CITY OF ALBUQUERQUE

March 11, 2025

**Re: Mesa del Sol Artiste Residential Development
Draft Traffic Impact Study (R15D003A)**
Engineer's Stamp DRAFT February 2025
Via email: jkruse@lee-eng.com and ABQ-PLAN

The subject Traffic Impact Study (Study) draft received on February 7, 2025, has been reviewed by the City of Albuquerque Planning Development Transportation Section and provides the following comments.

Figure 1: Site Plan

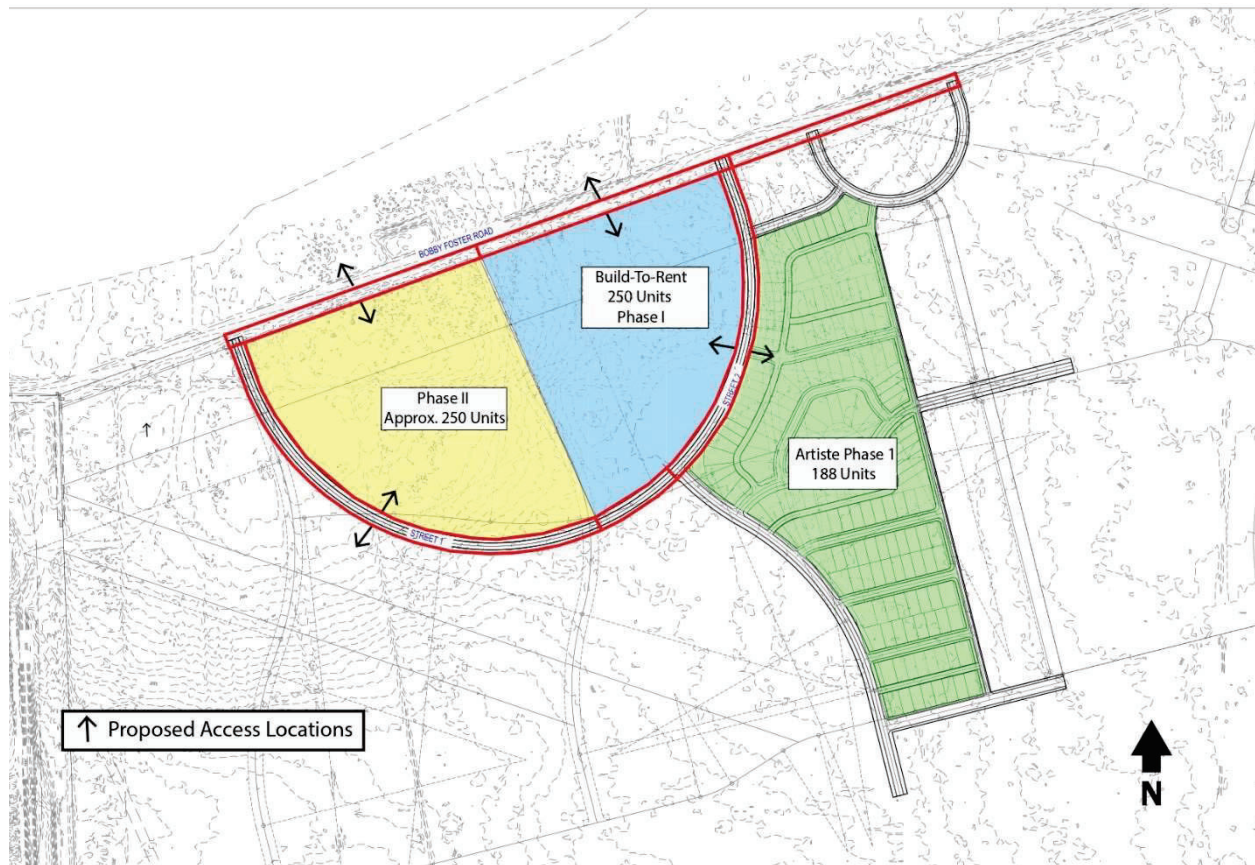
2. Scoping memo requires 11"x17" site plan. Site plan to show approximately 688 lots with a street network. Provide distances between intersections on Bobby Foster Rd and on N-S street along west side of Artiste Phase 1. Provide distances from Street 2 and Street 1 to Diebenkorn Rd on New Bobby Foster Rd.

- a. The Site Plan appears to show too many roads from Artiste Phase 1 intersecting the N-S major collector along its west frontage. Redesign it so there are less.

- b. Include a Figure and a discussion of how the roadways connect to the existing roadways east of this subdivision.
 - c. Artiste Phase 1 to construct DeKooning Ave to the existing DeKooning (CPN 775445) Ave to the East.

- d. Why are the block length so short at the south end?
 - e. Why is the subdivision shaped like this? It does not appear to be currently platted this way.
